Your Ref: F/17/17/DOC

Town & Country Planning Act 1990 (as amended)
Town and Country Planning (Development Management Procedure) (England) Order 2015
Application for approval of details reserved by condition imposed under previous planning
permission F/15/16/PL relating to condition No. 3 (SUDs system), 4 (Landscaping Scheme) & 10
(Construction site set up)

1 - 4 Holm Oaks Land adj Northwood House, Burndell Road, Yapton

Landscaping Drawing

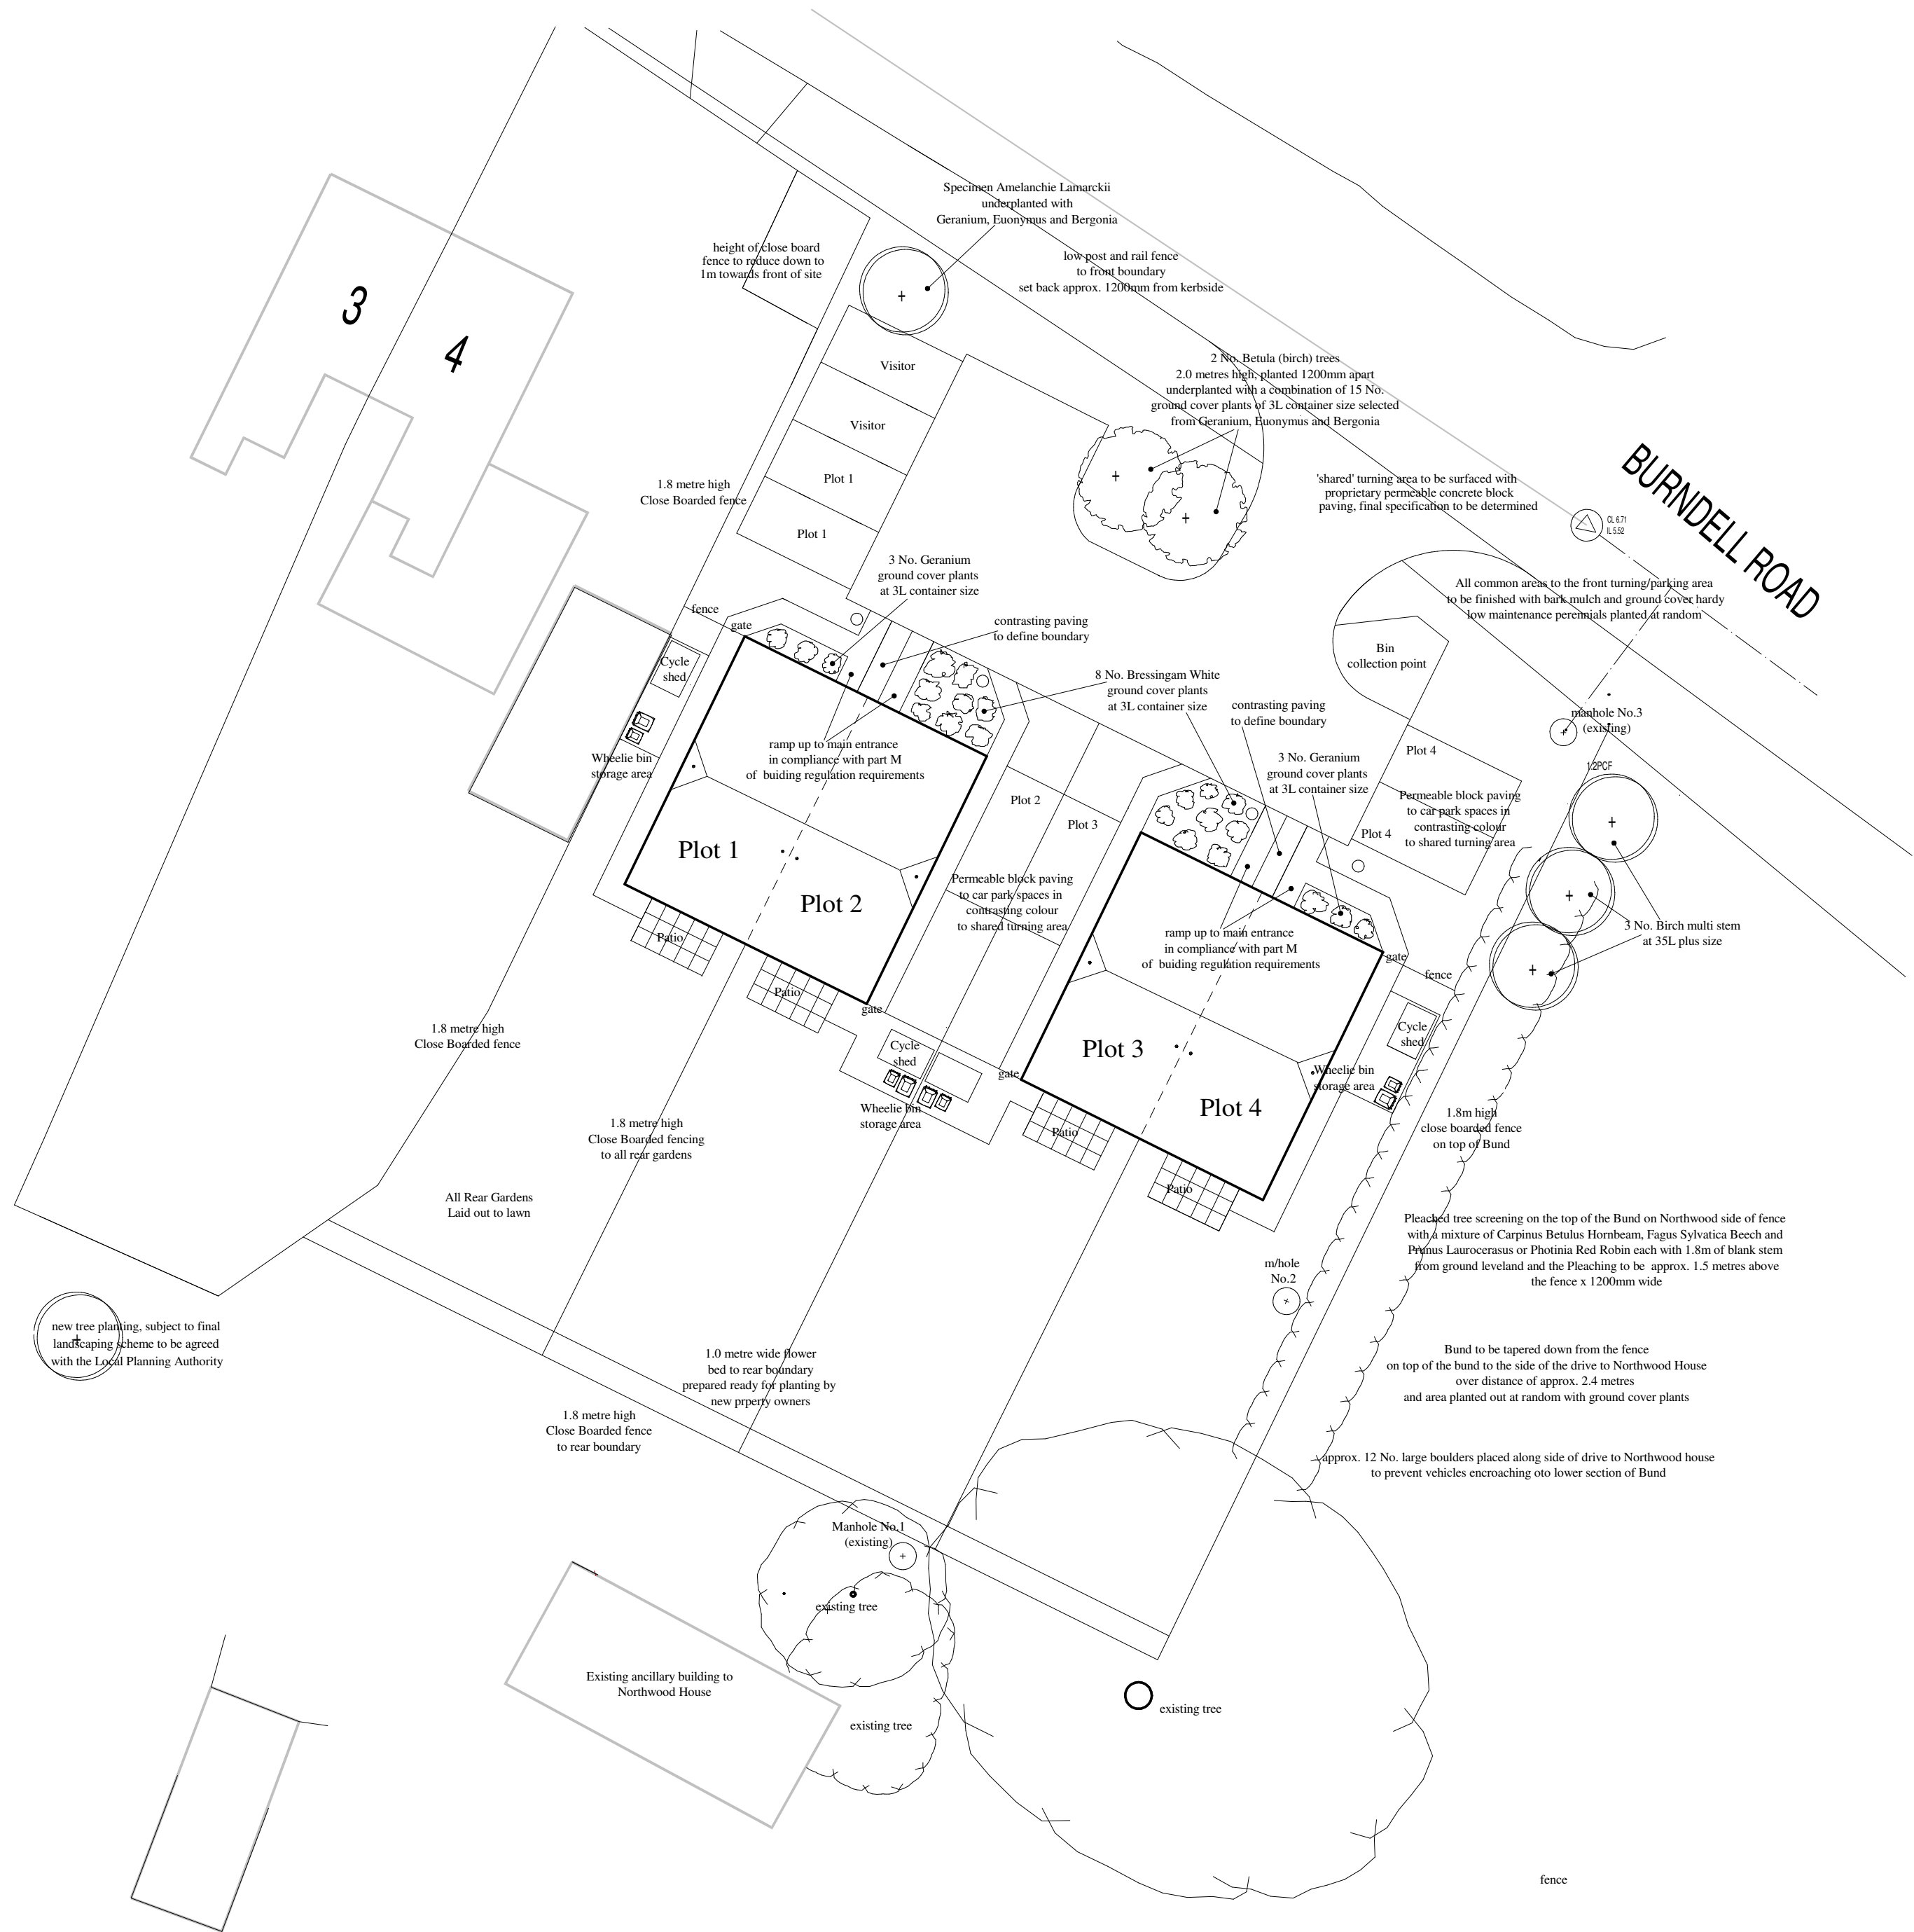
This condition cannot be discharged since no protection details relating to retained trees have been submitted as part of the proposal.
